From: Amanda Scholes on behalf of Planning.Responses
Sent: 07 September 2018 08:19
To: Planning Scanning
Subject: FW: URGENT - RE: A/23/18/DOC - Broadlees, Dappers Lane, Angmering
Attachments: Tree Protection as Built CAD 2010-B16005.101.pdf

From: Anita Gardner
Sent: 06 September 2018 15:16
To: Planning.Responses
Subject: FW: URGENT - RE: A/23/18/DOC - Broadlees, Dappers Lane, Angmering

Subject: RE: URGENT - RE: A/23/18/DOC - Broadlees, Dappers Lane, Angmering

TREE PROTECTION (Plan 3A)

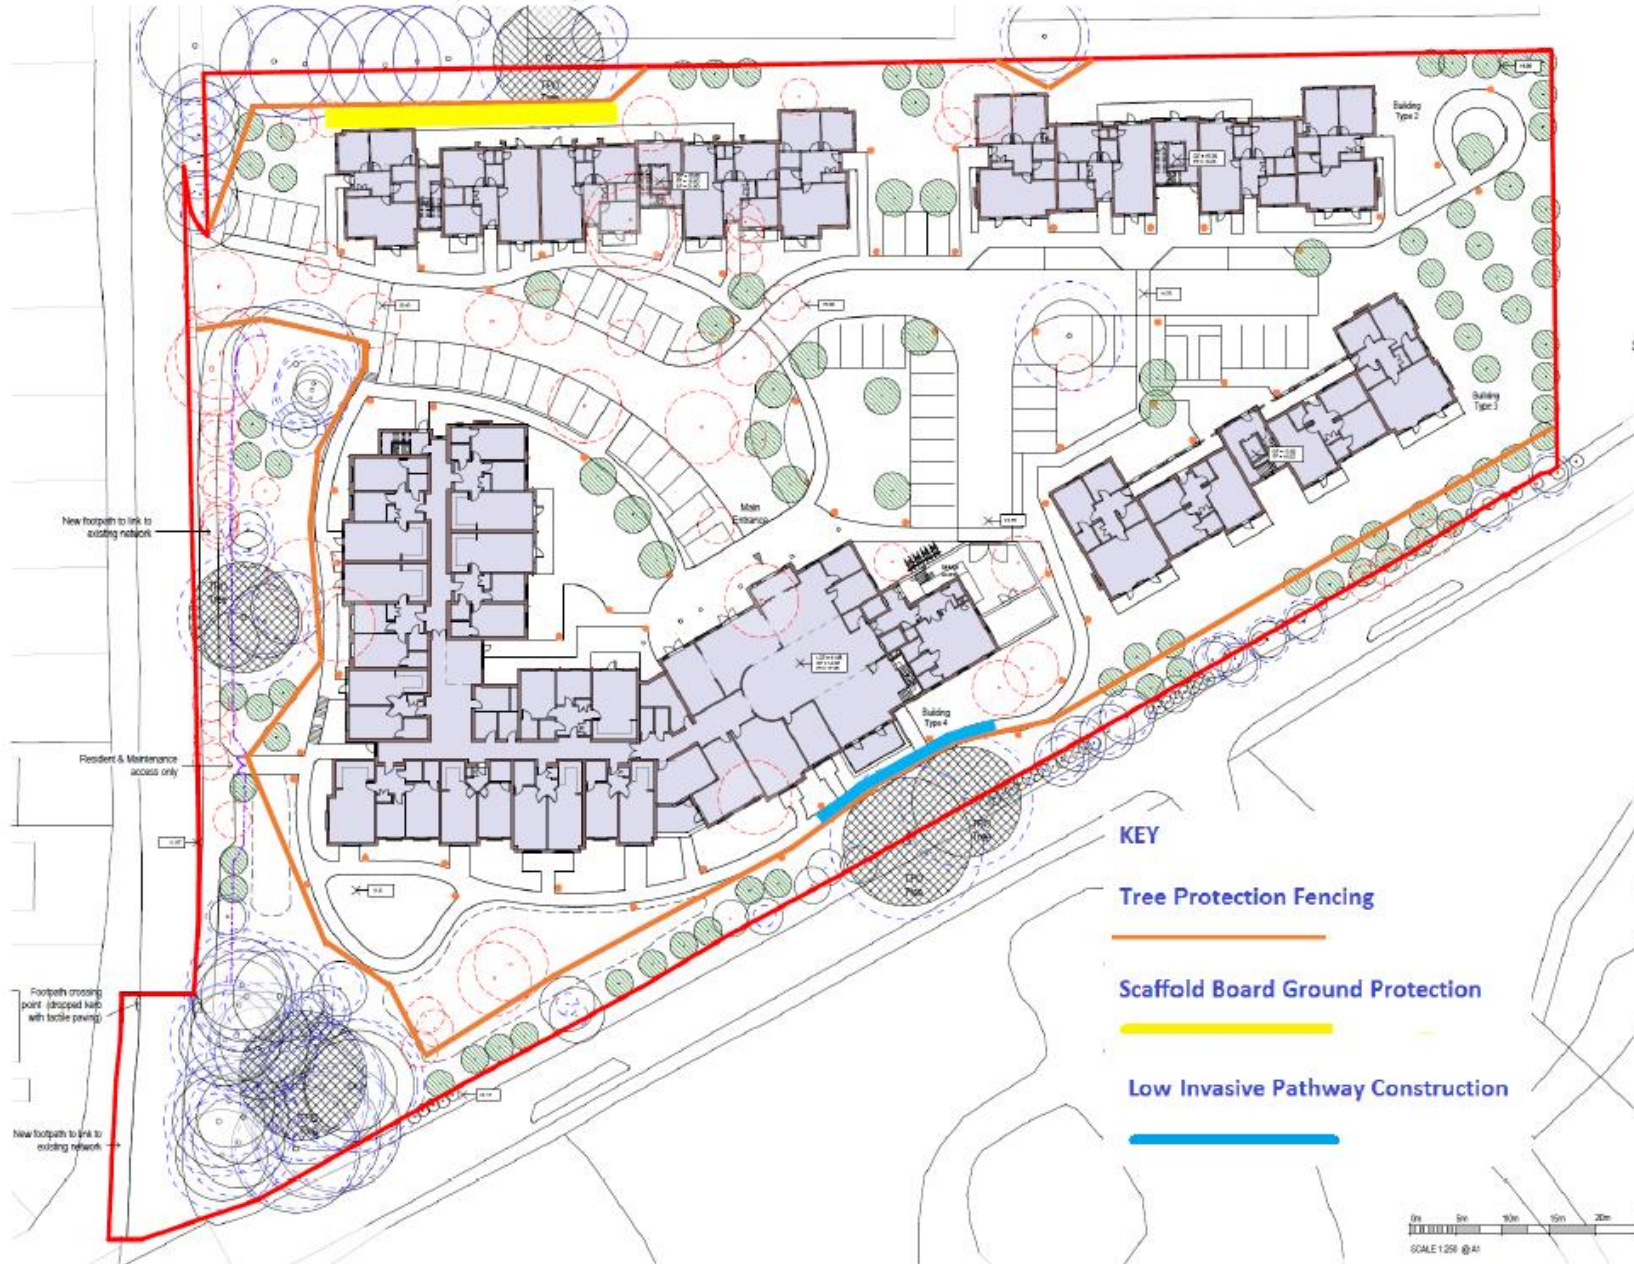
In the absence of general vegetation clearance and erection of Protective Fencing the Condition has not been complied with and I am therefore unable to sign it off at this time.

I note that the applicant has submitted a Tree Protection Plan Ref: Plan 3A – the measures set out on this plan are acceptable but will need to be implemented and then a Pre-Commencement Meeting can take place [at a mutually convenient time] between the applicants representative and the Arun DC Tree Officer to agree that the Protective Fencing complies with BS5837 recommendations and is 'Fit For Purpose' and that it has been erected exactly as shown on Plan 3A".
